# CITY OF ALBUQUERQUE

March 7, 2016

**Re: Papaya Place  
Erosion Sediment Control Plan  
Engineer's Stamp Date 2-24-16 (E19E021A)**

Erosion Sediment Control Plan

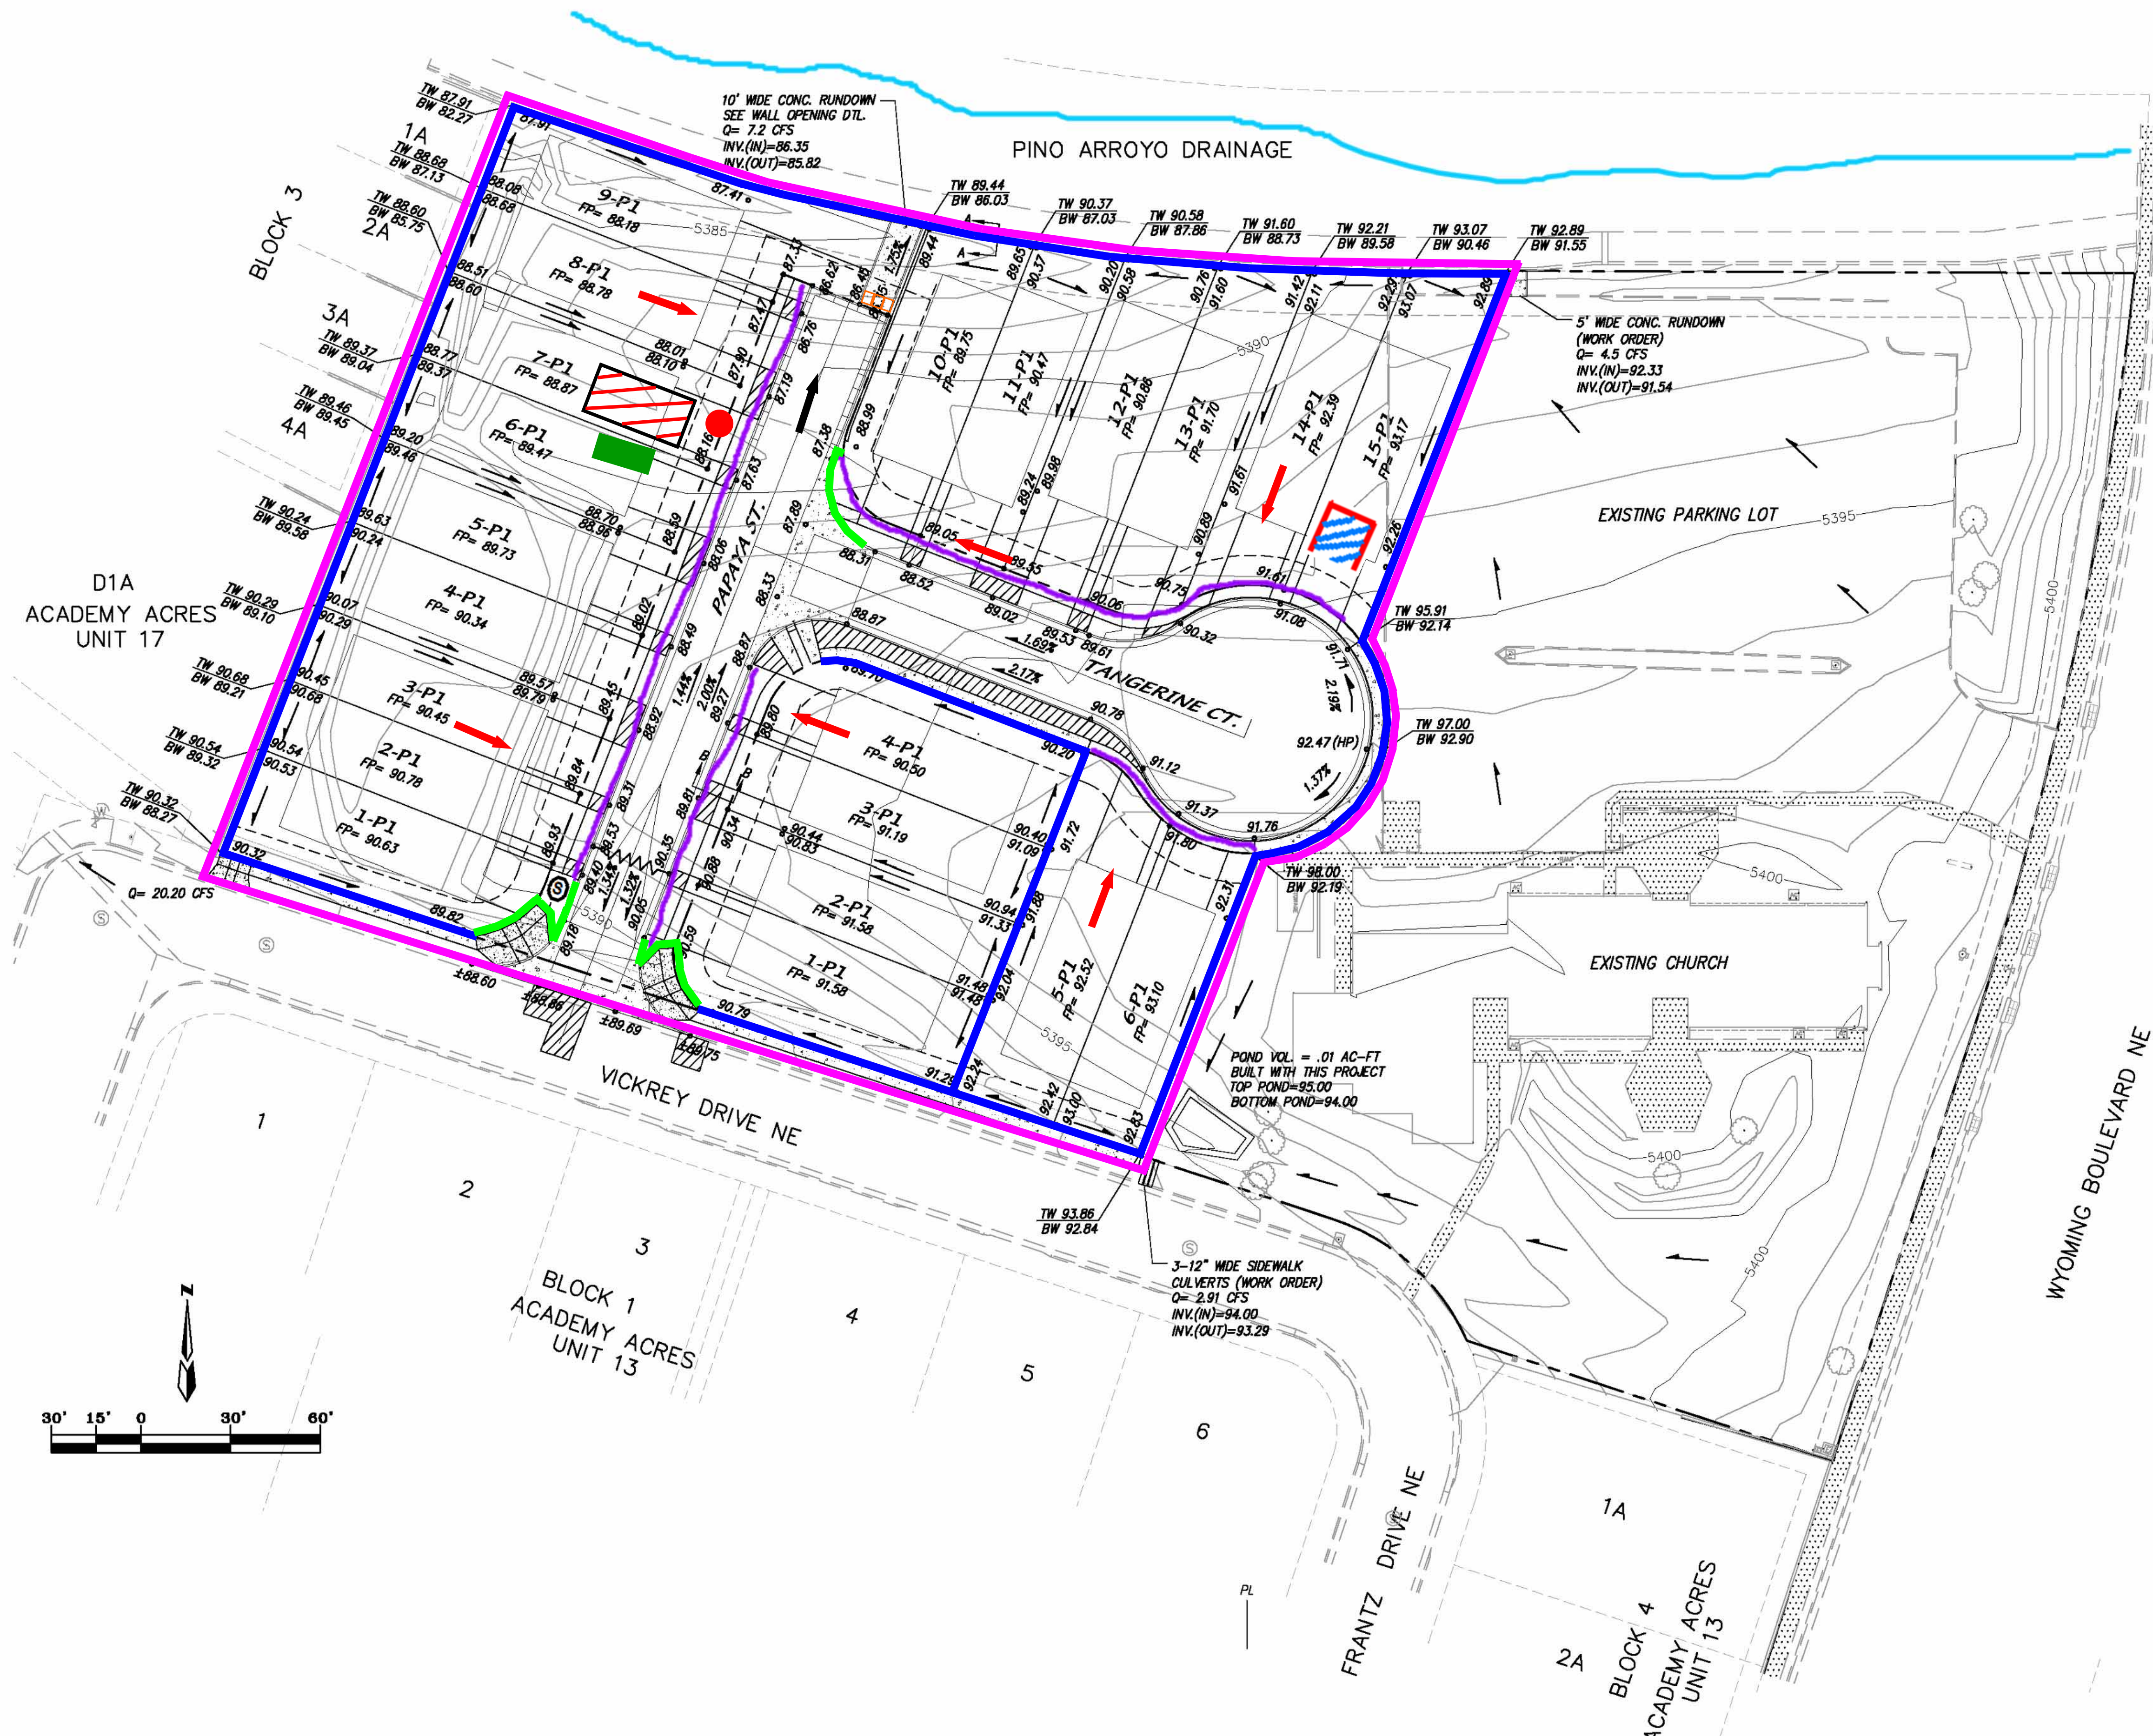
A. A similar ESC plan, Mark Goodwin and Associates stamp date 2-23-16, was approved for this project. Slight differences between the plans are the Goodwin plan:

1. Showed the wattle across the rundown.
2. Specified the wattle on the channel sill.
3. Included a couple of construction notes (I've sent a list).
4. Included wattles in the front yard swale of Papaya Street.
5. Includes a sediment pond at the front of each lot.
6. The plan also had the project name as Fruita Del Sol.

Stormwater Quality can choose to inspect to this approved plan or to the approved Mark Goodwin and Associates plan as it includes additional BMPs.
